Project name	Gavray Drive, Bicester		
Design note title	Response to EA Comments		
Document reference	15114-HYD-XX-XX-TN-FR-5005 P05		
Author	Simon Mirams		
Revision	P05		
Date	17 February 2022	Approved	✓

1. INTRODUCTION

The EA response has highlighted 3 points and for the purpose of this note each of the topics raised forms a subject heading with a response to each point.

TITLE
**CUT AND FILL STRATEGY
SHEET 1 (WESTERN DEVELOPMENT)**

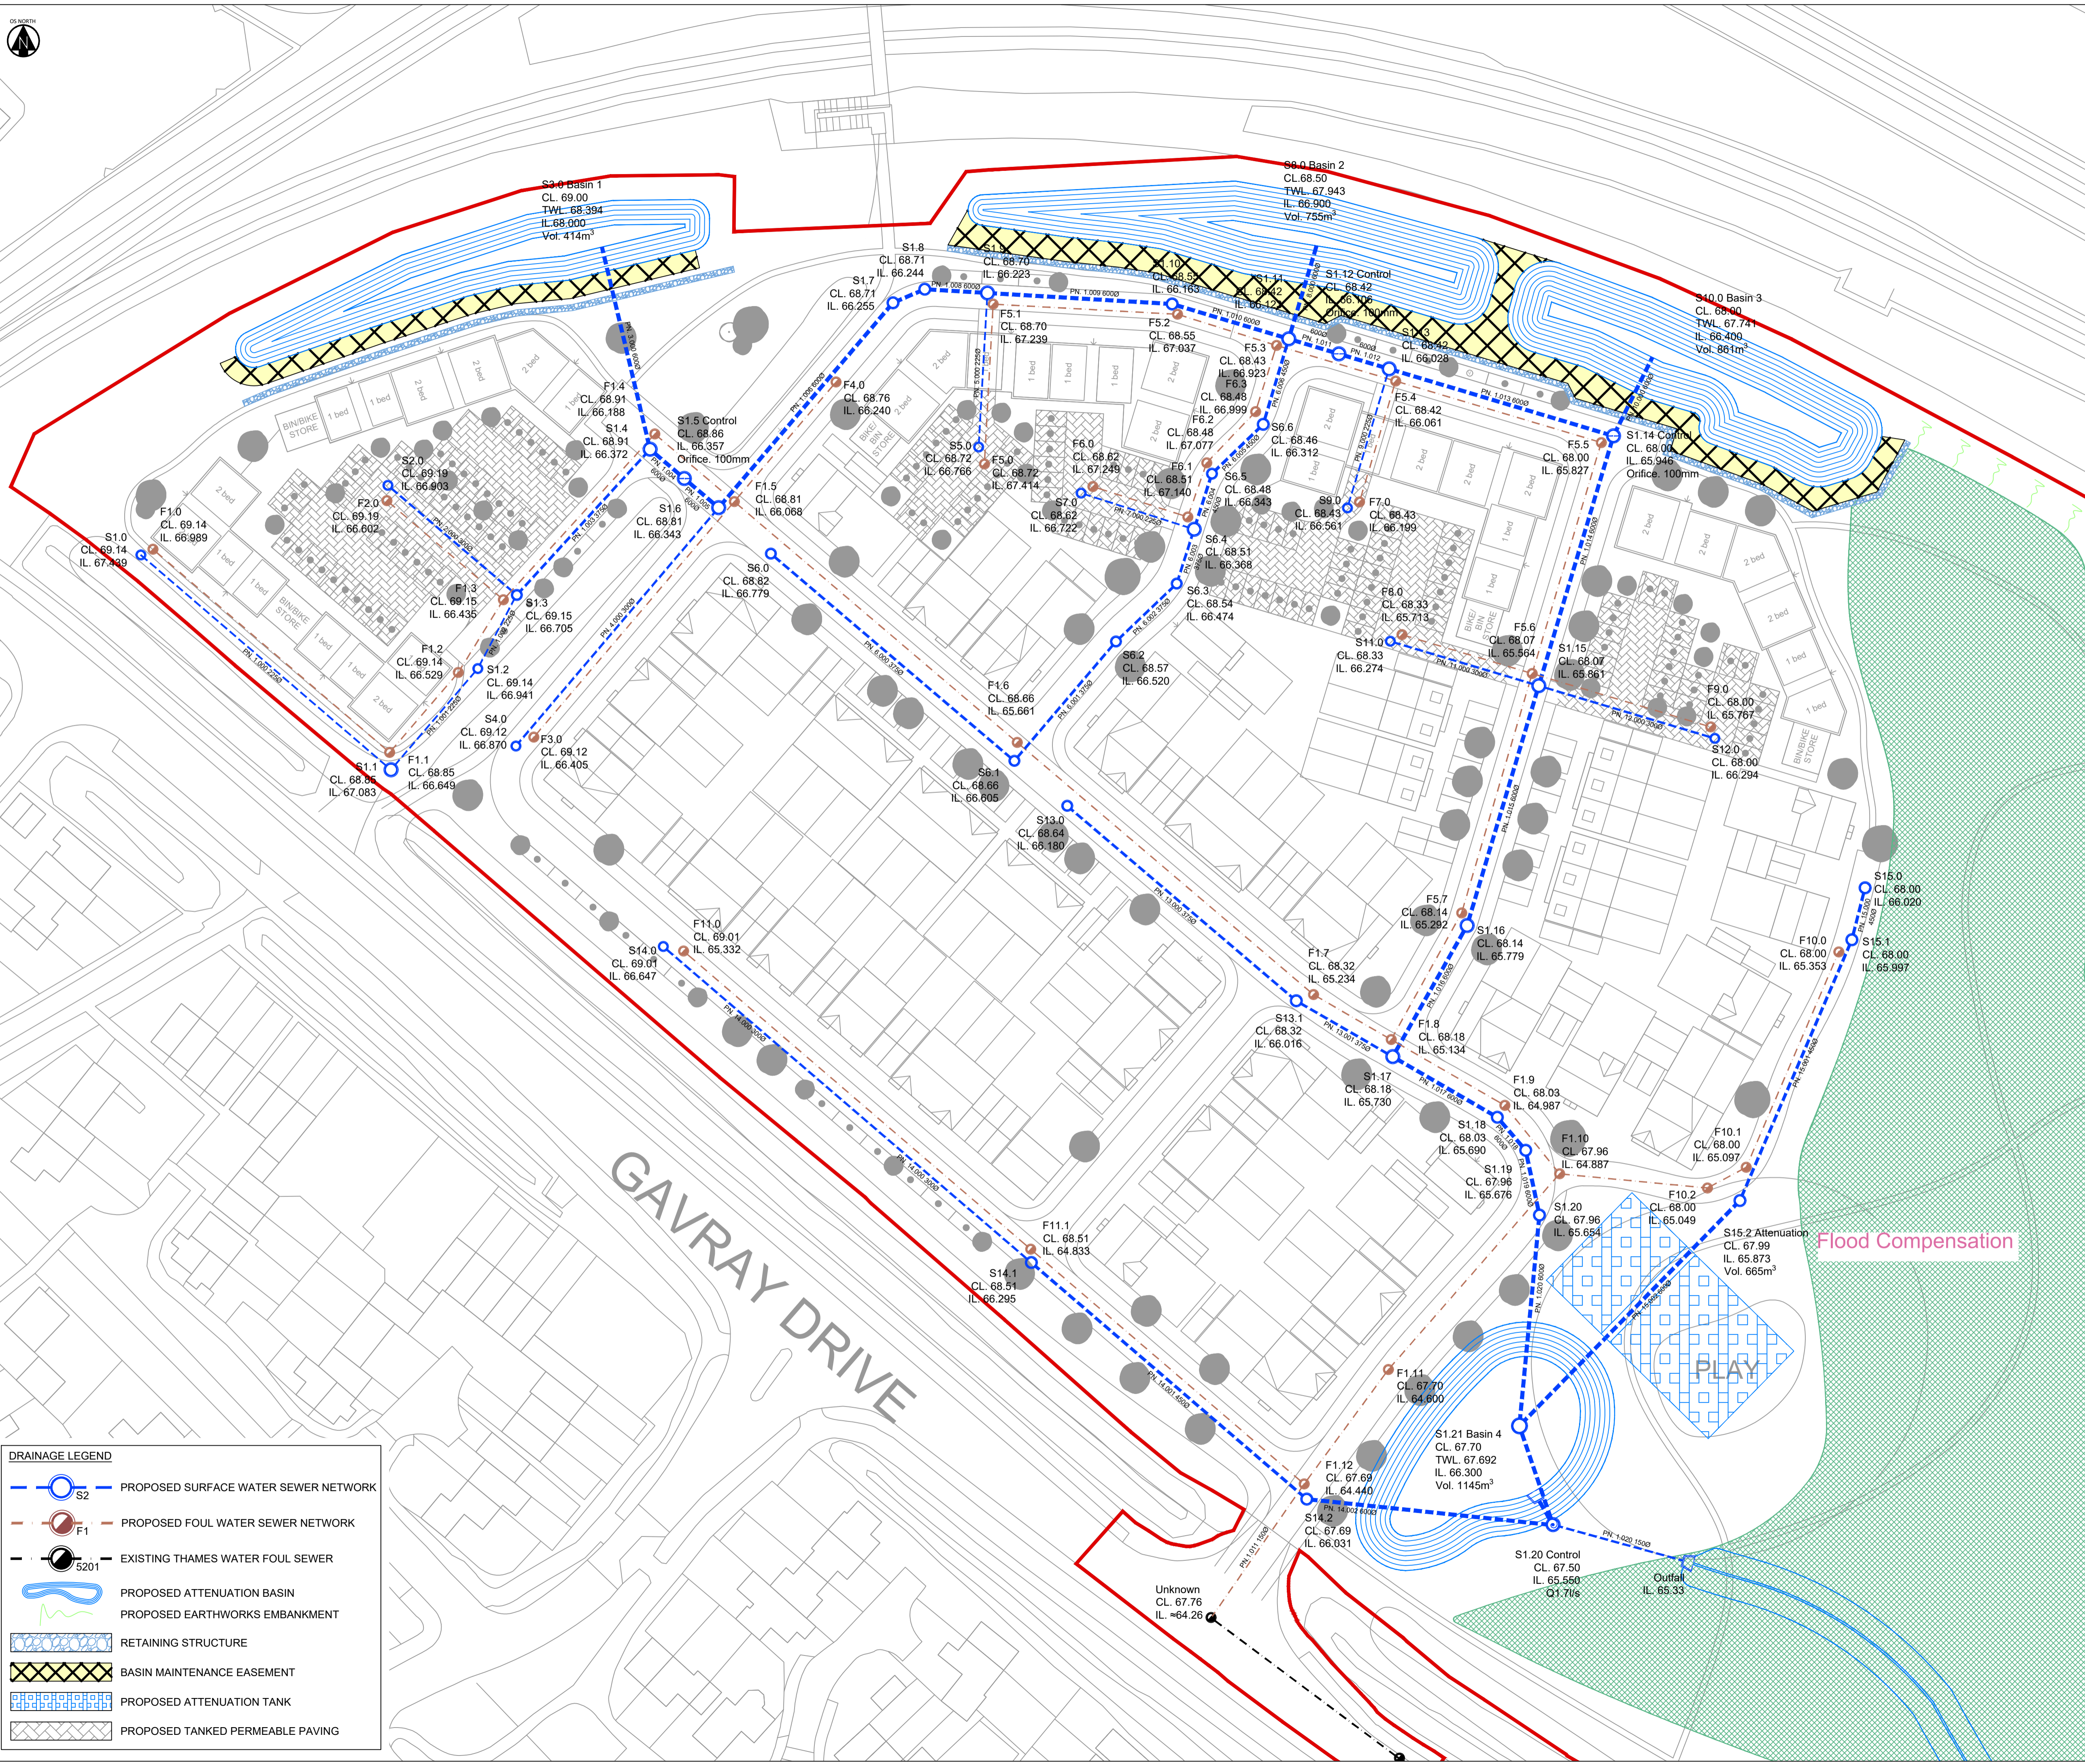
In summary the proposals are, and in line with best practise, for these sections of the site to be raised to ensure all finished floor levels are a minimum of 600mm above the 1 in 100 year plus 35% allowance for climate change event (which it should be noted exceeds the current guidance for the Langford Brook which required a 20% increase) and set no lower than 67.62m AOD. It is also recommended that all ground levels (including access roads, domestic garden, drainage infrastructure etc) be set a minimum of 300mm above the 1 in 1,000-year flood levels which would be a minimum level of 67.47m AOD. In adopting this approach, and through providing the proposed compensation storage, all development will be located within the post development Flood Zone 1 and at low risk.

Where the required levels result in ground raising this would effectively result in a 'loss' of floodplain storage and a scheme of floodplain compensation would be required to ensure no increase in flood risk and, where possible, a betterment elsewhere. Such works comprise the lowering of ground levels between the Gavray West development parcel and the Langford Brook to a level of 66.5m AOD to tie in with the proposed surface water drainage outfall.

Detailed modelling of the proposed floodplain compensation scheme has demonstrated the site will not increase flood risk within the catchment through a loss of floodplain storage or impedance of flood flows. A detailed explanation of this is given within the submitted FRA but a volumetric assessment has also been conducted for the post development scenario based on the maximum pre- and post-development fluvial flood volumes during the 1 in 100-year event plus 35% climate change. This assessment indicates a requirement for flood water storage of 21,603m³ and 23,569m³ for pre- and post-development respectively. As such, an **additional 1,966m³** of storage is provided and therefore a **betterment** when compared to the existing scenario

The modelling undertaken confirms that whilst sections of the site are currently shown to be within Flood Zone 3 suitable mitigation measures have been modelled that confirms through provision of compensation storage all development can be located within Flood Zone 1. The FRA also details how the proposed ground lowering/compensation storage provided a **betterment** on the current situation by providing an **additional 1,966m³** of volumetric storage on the site when compared to the existing situation.
